Consultation Response from KC, Highways Development Management - Mark Berry		
2020/94285 22-26, Wellington Road, Dewsbury, WF13 1HL		
Alterations to office building to form 20 flats and associated office space and laundry (Listed Building within a Conservation Area)		
Date Responded:20-07-2021	Responding Officer: Mark Berry	Responding Ref: 15-2NW-3

This application seeks approval to the alterations to office building to form 20 flats and associated office space and laundry at 22-26, Wellington Road, Dewsbury

Dwg. No. 556.22 (--) 002

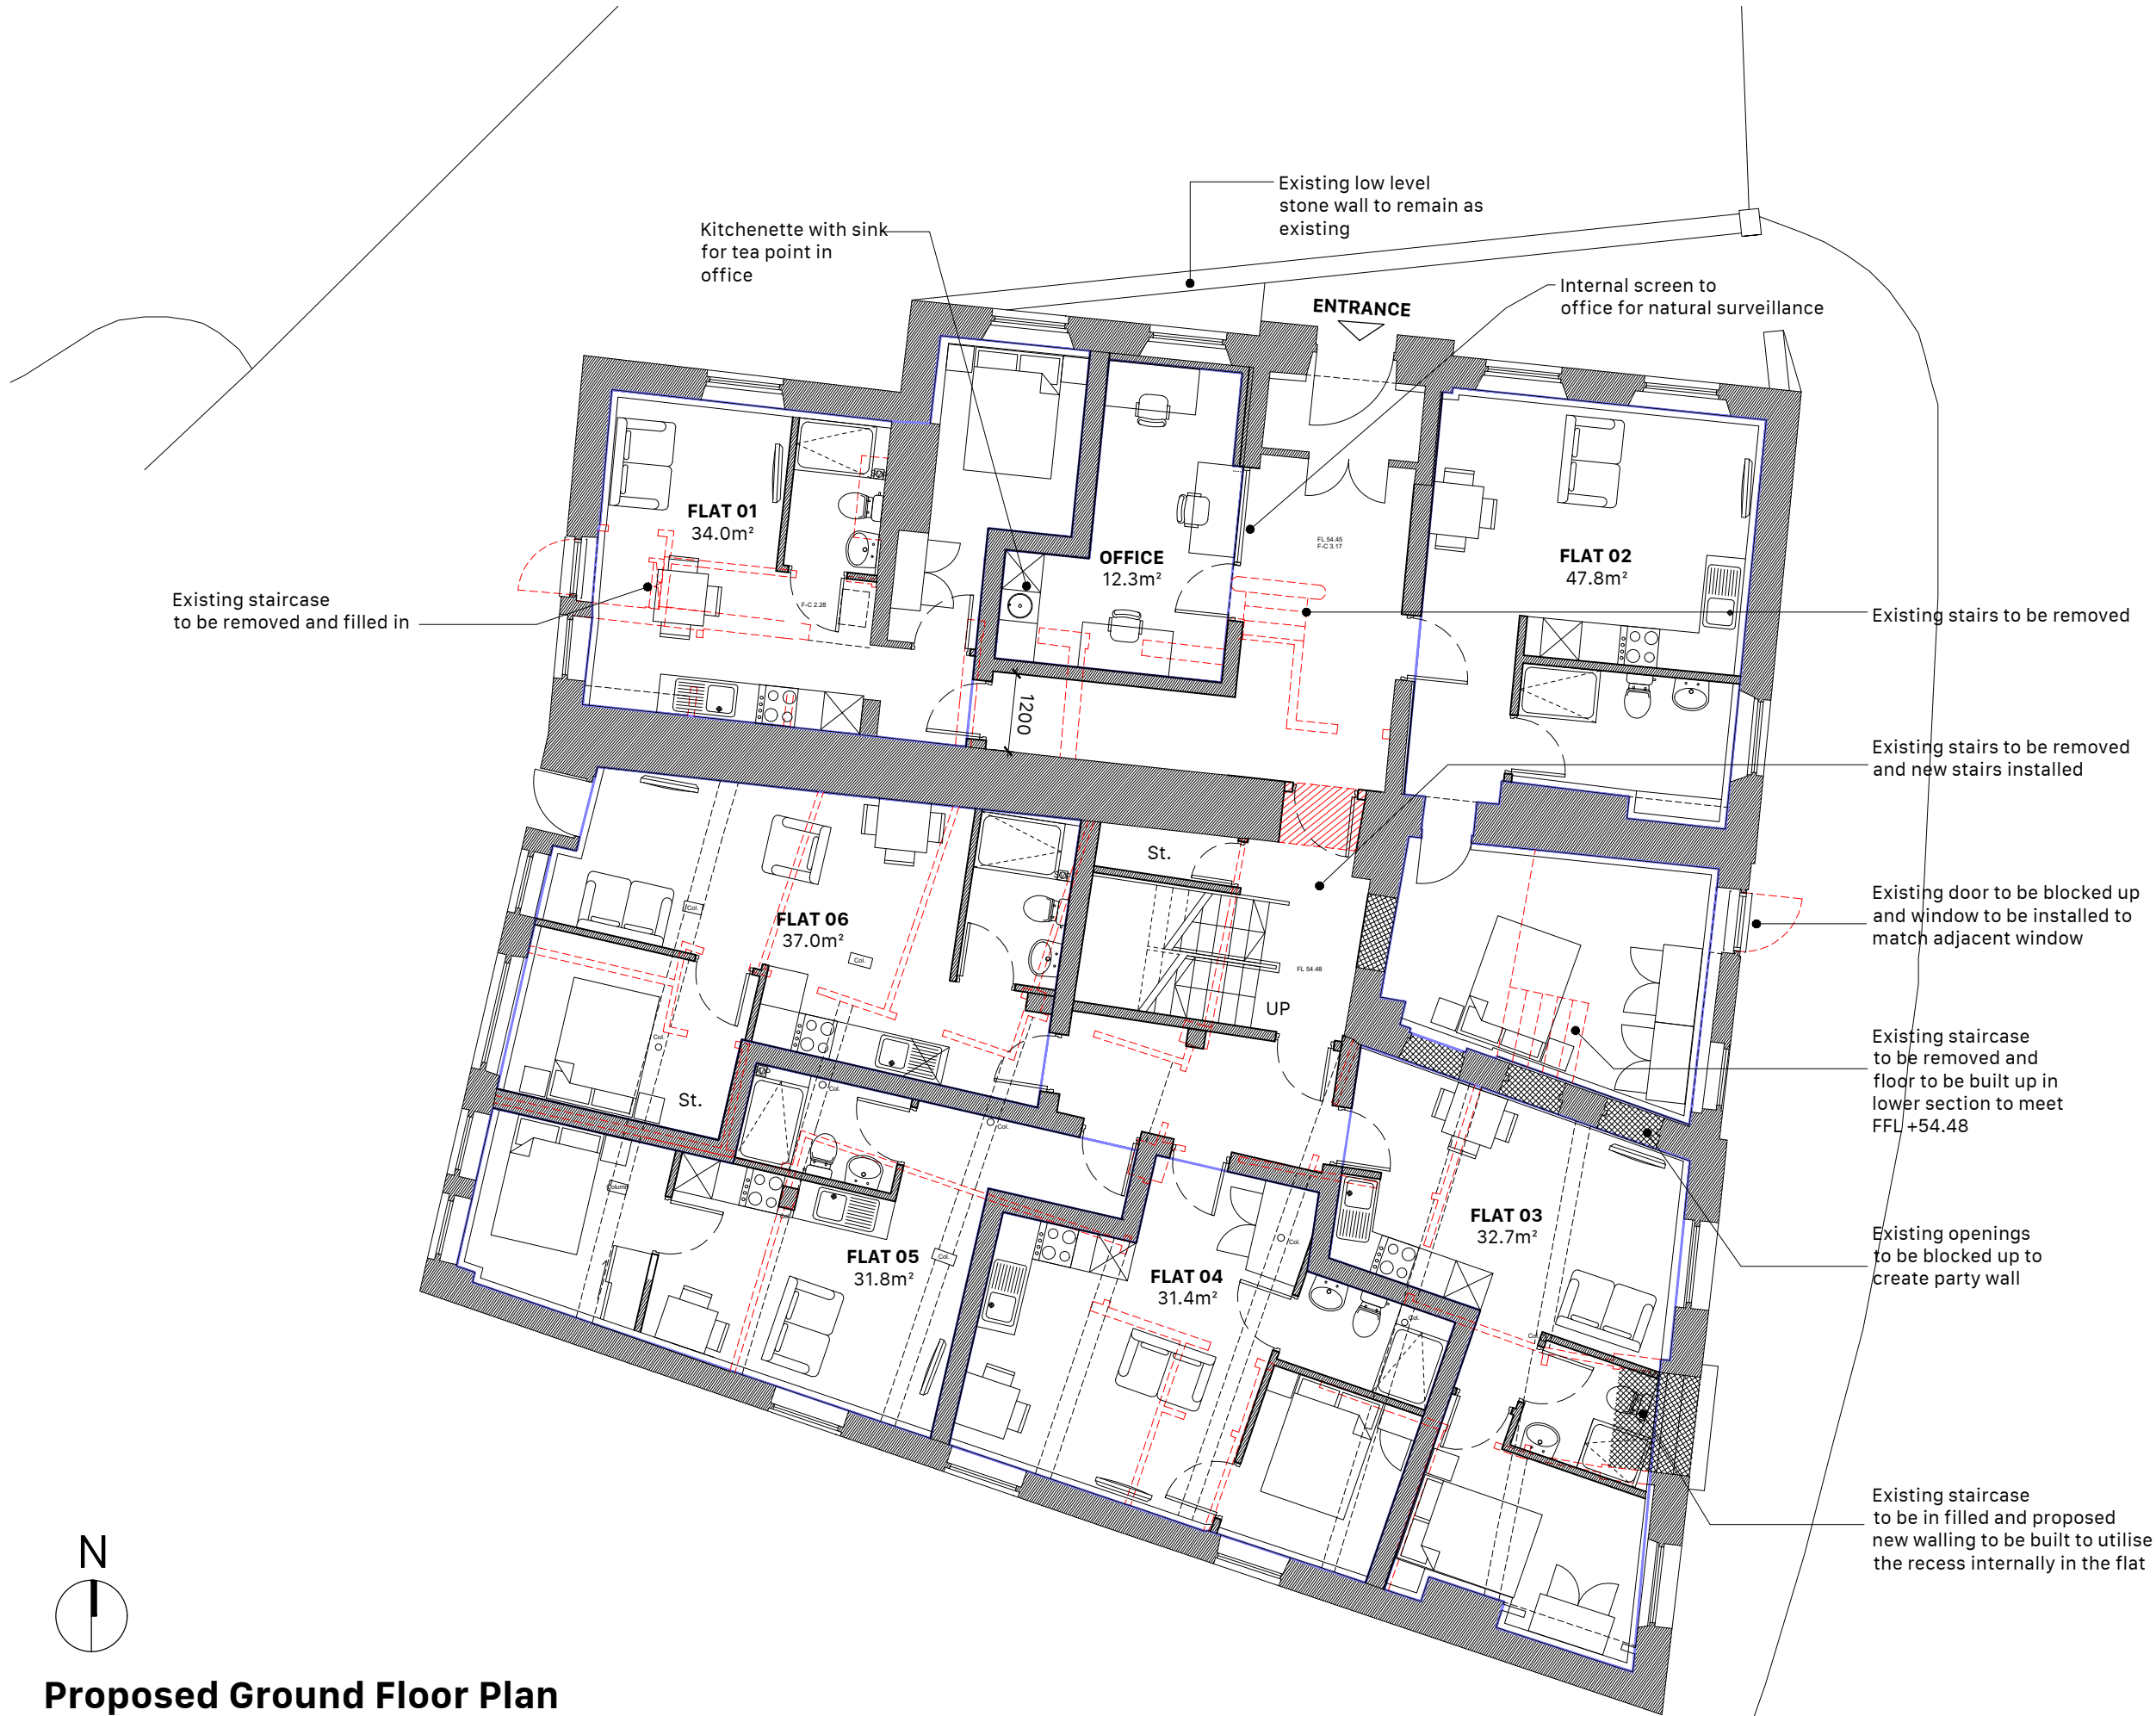
1, No details of the of the proposed servicing arrangements are provided. The comments from Waste Strategy are attached.

2, The red line boundary includes a small forecourt to the site frontage with access from Wellington Road and Dewsbury Ring Road.

No information is provided to explain how this area will be used and no plans are provided to show how this area will be marked out.

3, No details of any proposed provisions for cycle parking are provided.

These proposals only show three 1100ltr Eurobins which is insufficient based on KC Waste Strategy recommendations for this site.

The applicants have provided amended plan number 556-22(--)/007 showing the small forecourt to the site frontage with access from Wellington Road and Dewsbury Ring Road marked out to include 2 off-street parking spaces and bin and cycle storage. 3 1100L bins are shown.
